Your ref:	Installation of air condition...	<b>Please reply to:</b>	<b>Rayhan Ali</b>
Our ref:	21/06002/FULL	Tel No:	07866033247
		Fee Queries:	0207 641 6500;
		Email:	planningreception@westminster.gov.uk;
Mr Andrew Lester P. D. Associates 3 Pitcairne Court 5 Donovan Place London N21 1RZ United Kingdom		<b>Incomplete Applications</b> Development Planning City of Westminster PO Box 732 Redhill, RH1 9FL	
		13 September 2021

**Address: Flat 35, Imperial Court, 55-56 Prince Albert Road, London, NW8 7PT,**

**Proposal: Installation of air conditioning unit on balcony.**

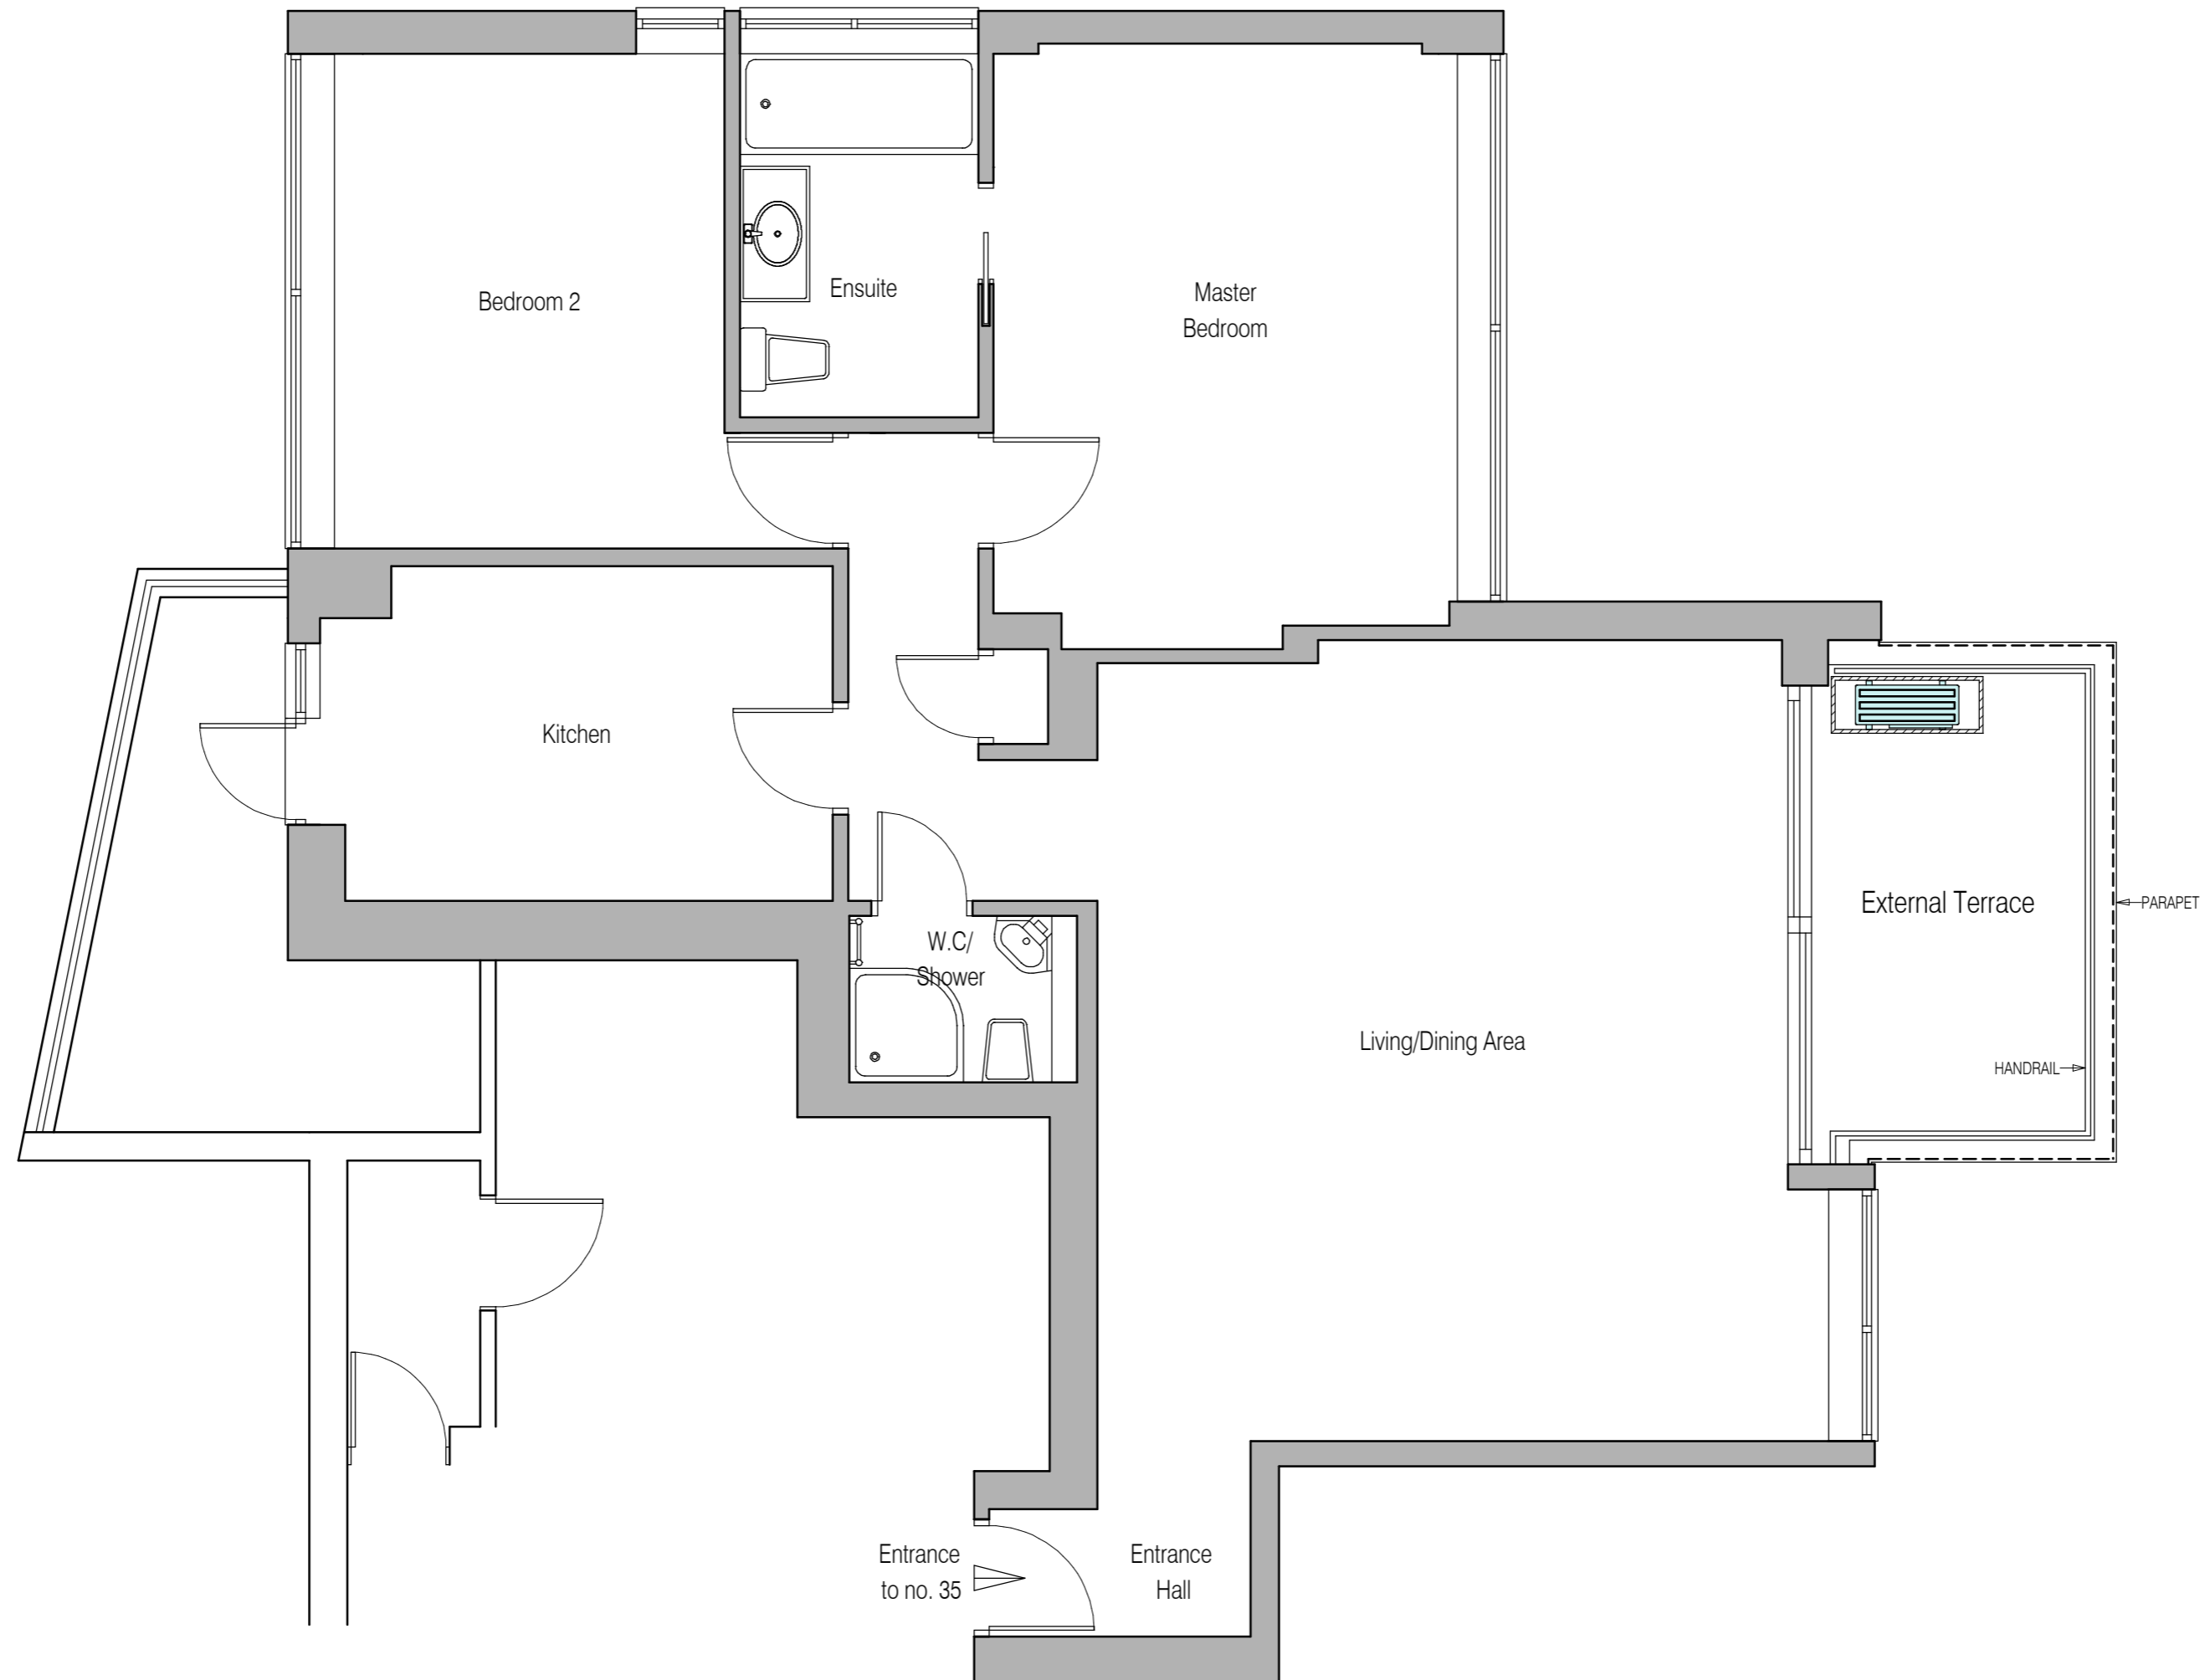
- 1 Please provide Existing Front elevation and section drawings.
  - 2 Some or all of the drawings submitted with your application do not include a scale bar, please amend. This is required as we have moved to an electronic way of working and no longer print paper copies of drawings.
  - 3 Please provide manufacturers specifications including technical data, size and colour of the proposed plant equipment.
- 0 \*Please collate all requested information in a single submission, and send to [planningreception@westminster.gov.uk](mailto:planningreception@westminster.gov.uk). Sending your documents individually will not speed up the process. Please do not upload to the planning portal as this causes duplication and may delay the processing of your application. Thank you.\*
